**RE: MINOR AMENDMENT TO PRE-DO APPROVAL – SITE DEVELOPMENT PLAN
TR 3-A-1 PLAT OF LOTS 3-A-1 AND 3-B-1 COORS VILLAGECONT 6.5543 AC
4500 QUAKER HEIGHTS PL NW ALBUQUERQUE NM 87120
IDO ZONE ATLAS PAGE F-11-Z**

Tierra West LLC, representing Ativo LLC, is formally requesting an administrative adjustment to a previously approved Site Plan for a property located at **4500 QUAKER HEIGHTS PL NW**. This property, legally described as **TR 3-A-1 PLAT OF LOTS 3-A-1 AND 3-B-1 COORS VILLAGECONT 6.5543 AC**, and currently zoned MX-L.

SITE PLAN FOR BUILDING PERMIT

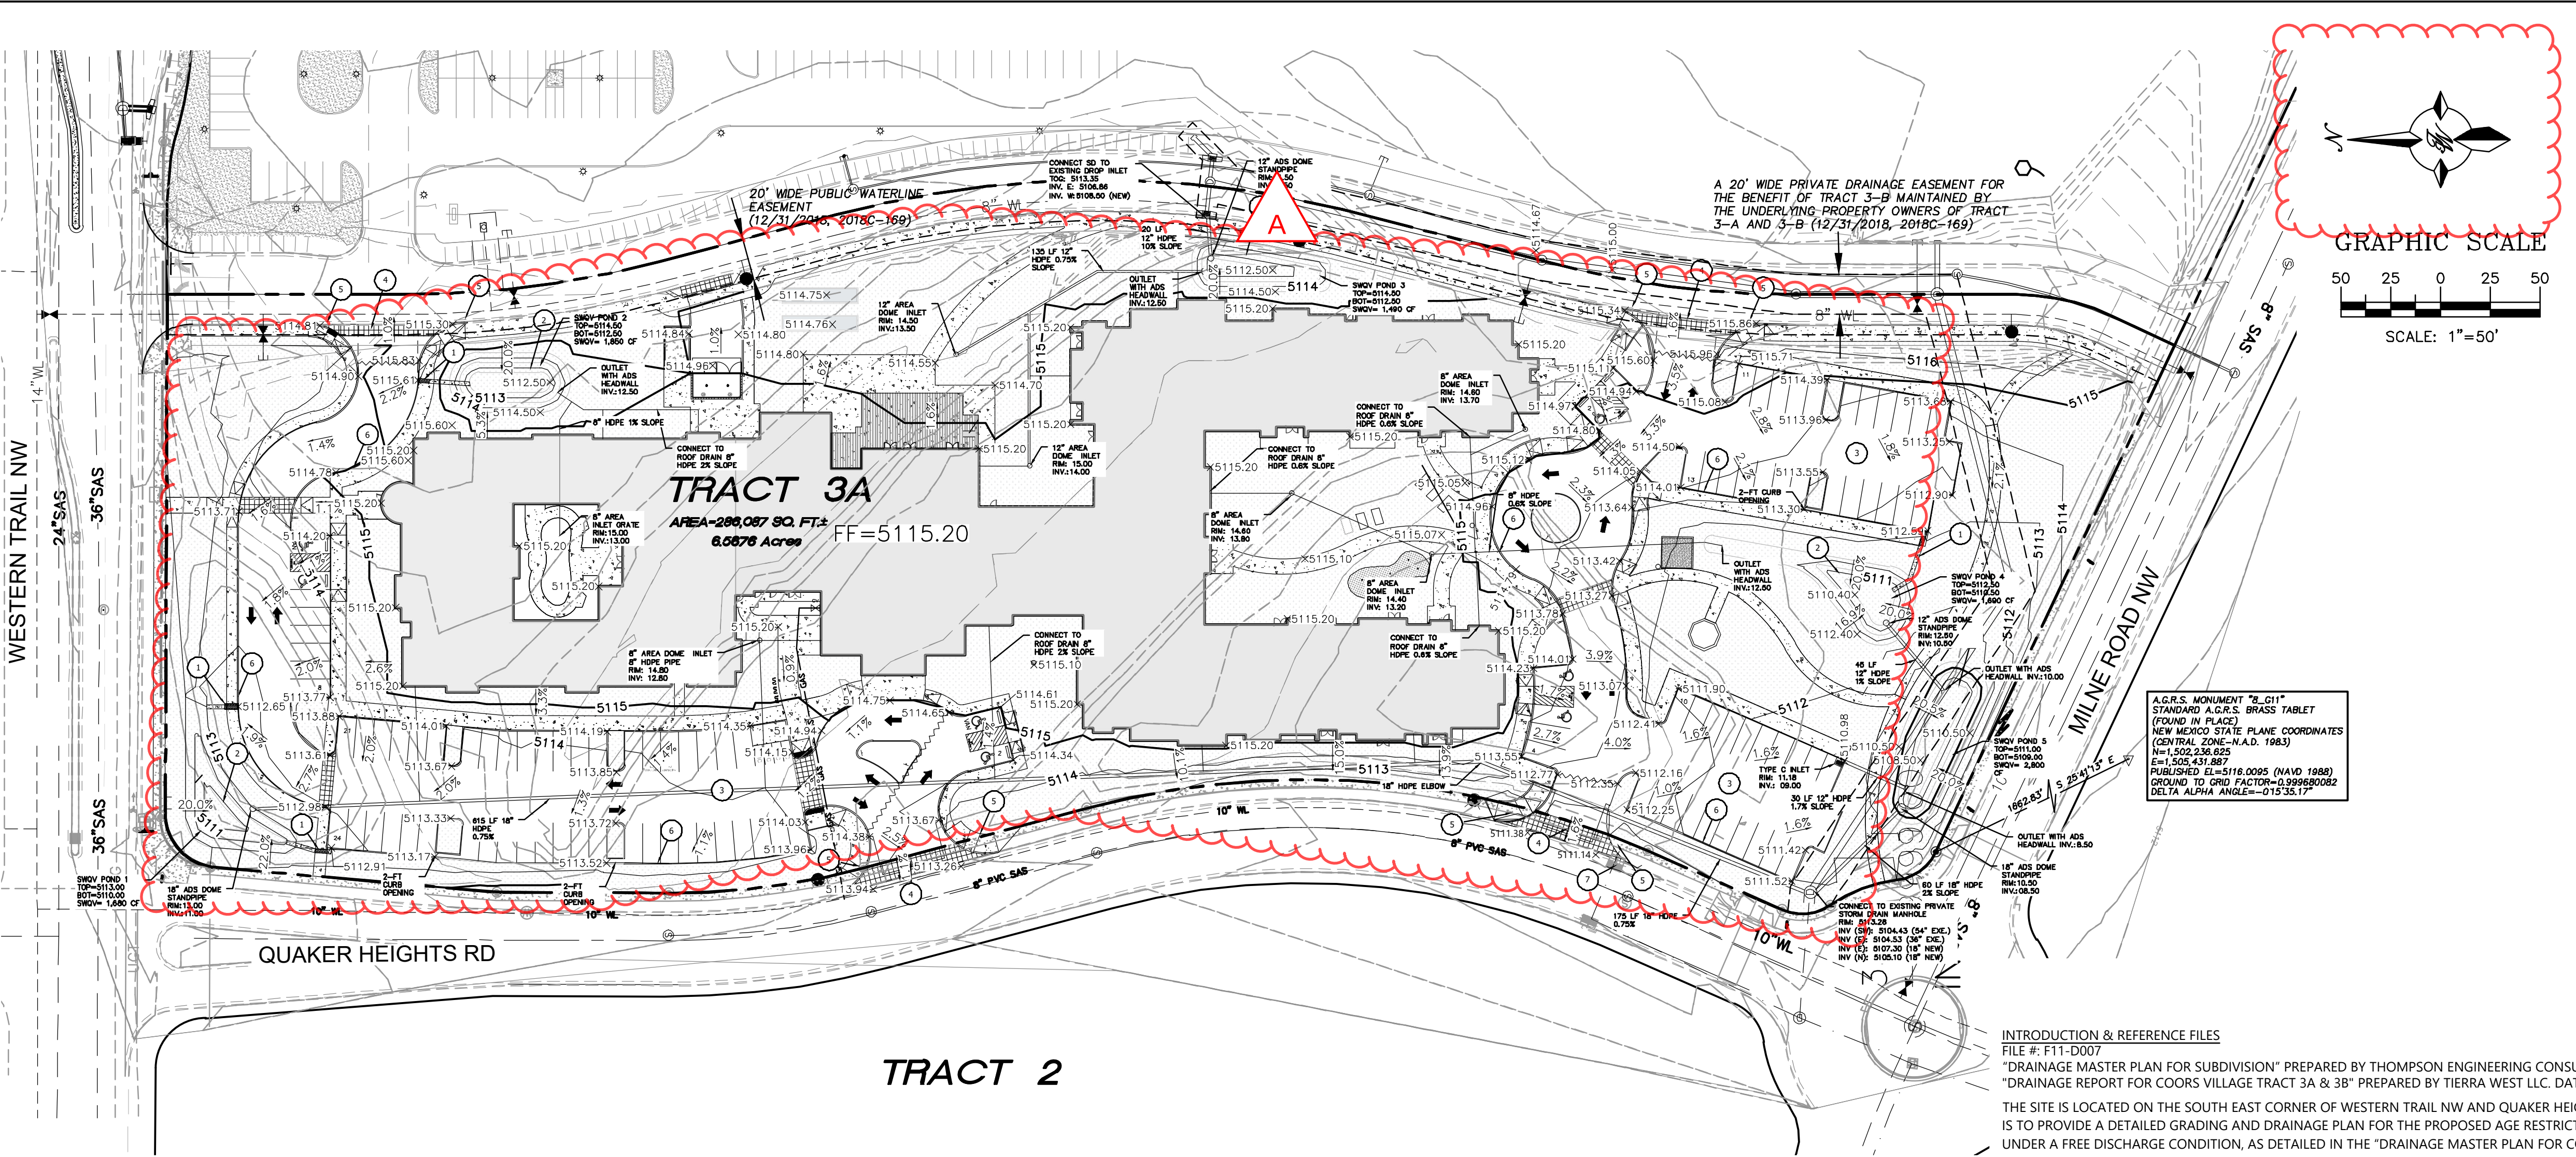
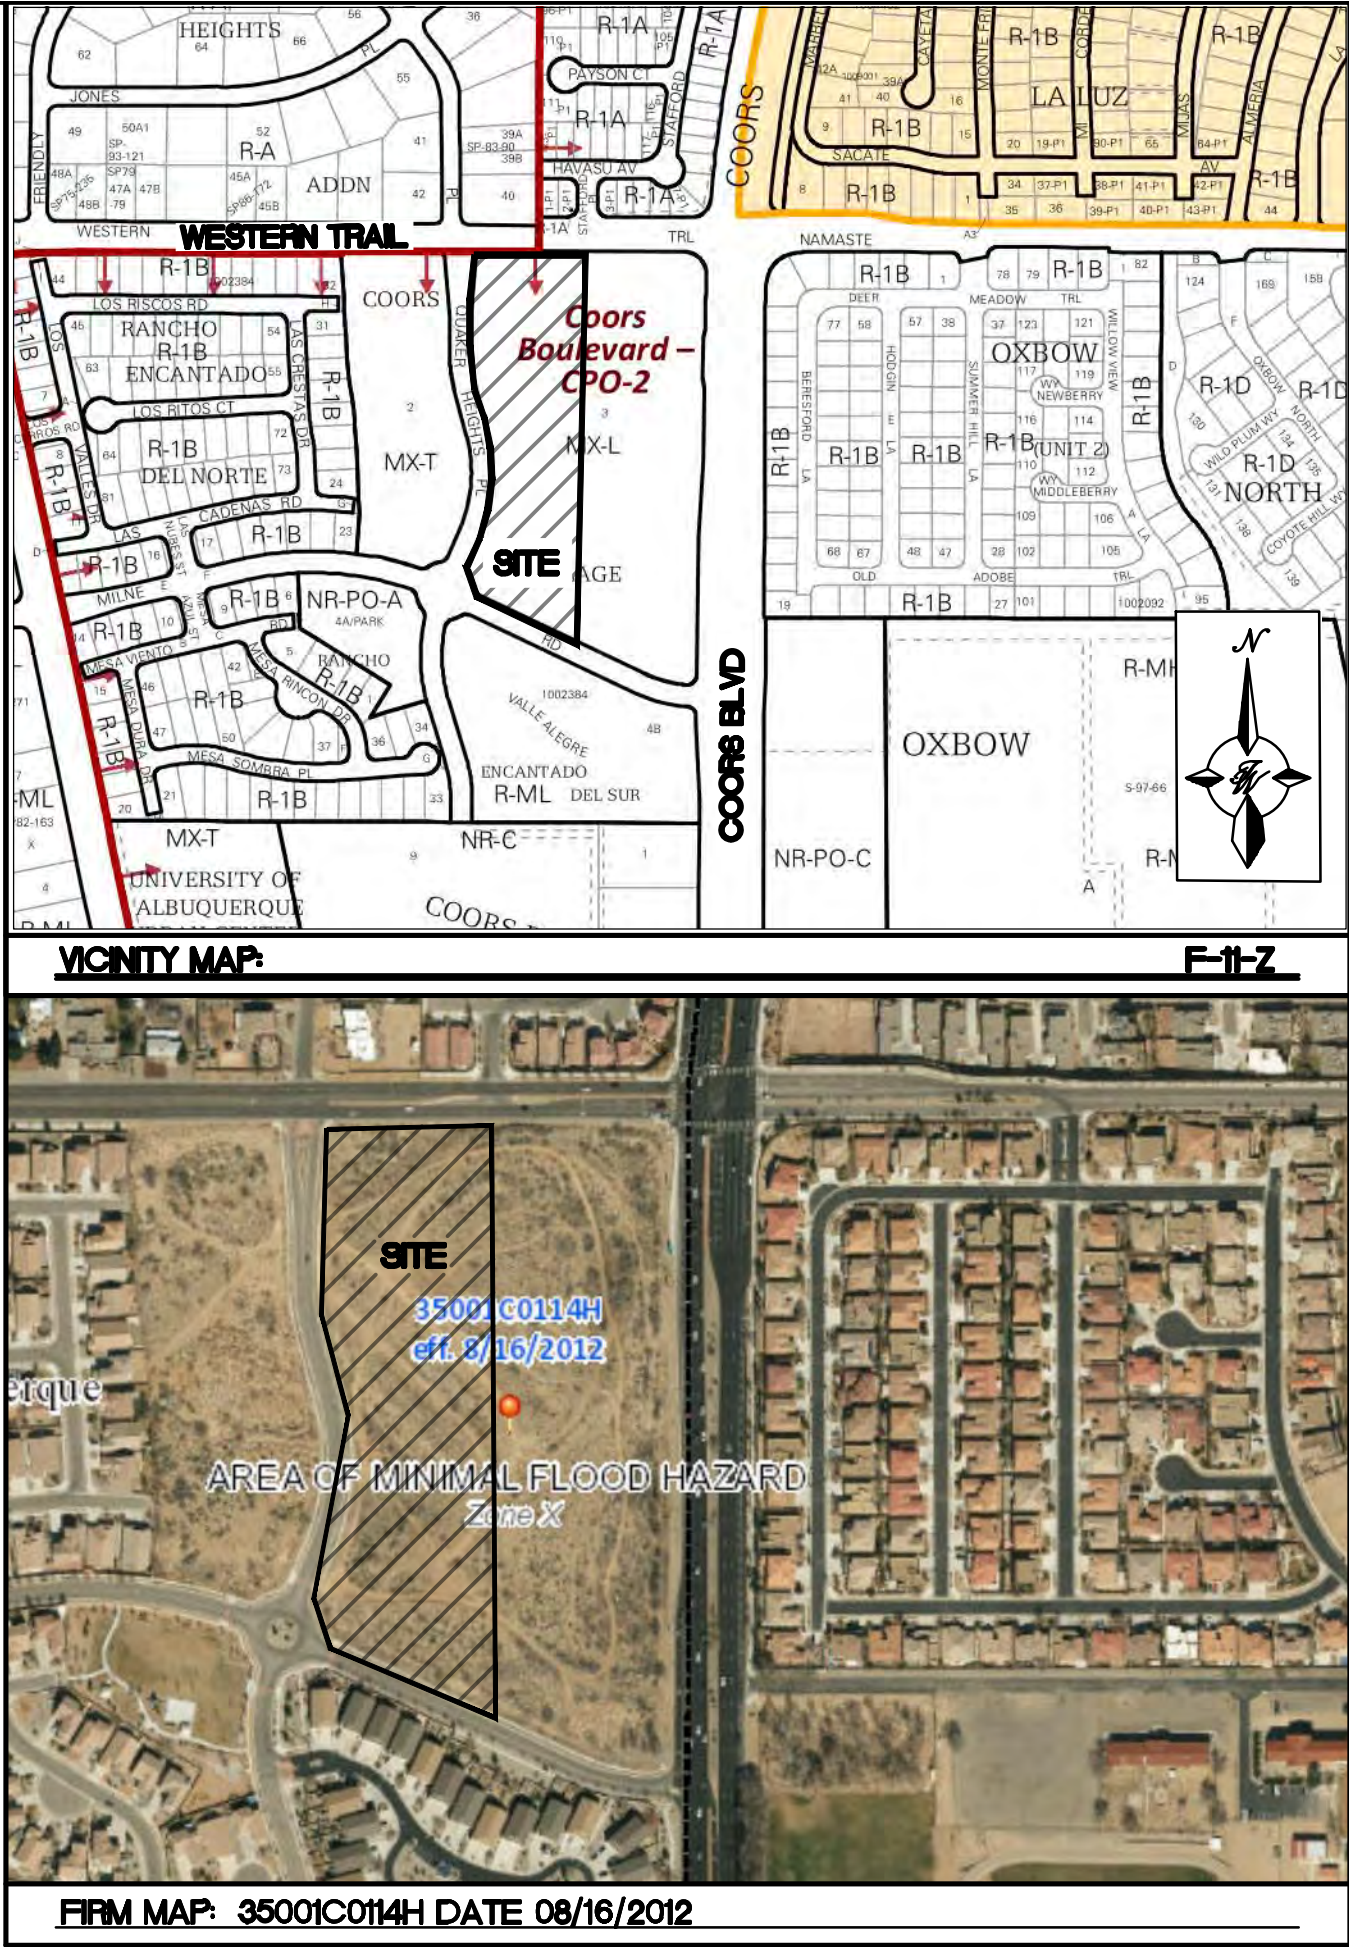
1. Removed ADA Curb
2. Reconfigured southwest sidewalk connection
3. Added ramp for ADA
4. Moved ADA Pedestrian Crossing to Top of Grade Break
5. Relocated sidewalk and light base to allow Fire Access
6. Added step to generator pad access
7. Removed ADA Crossing
8. Removed Pedestrian Connection to Quaker Heights Sidewalk
9. Reconfigure drainage slope
10. Monument Sign

The proposed monument sign is dimensioned at 8' -1 ½" x 5' – 6". This is smaller than the approved 8' – 2" x 8' – 0". The location is to remain as called out by keyed note 9 highlighted in red on the amended site plan.
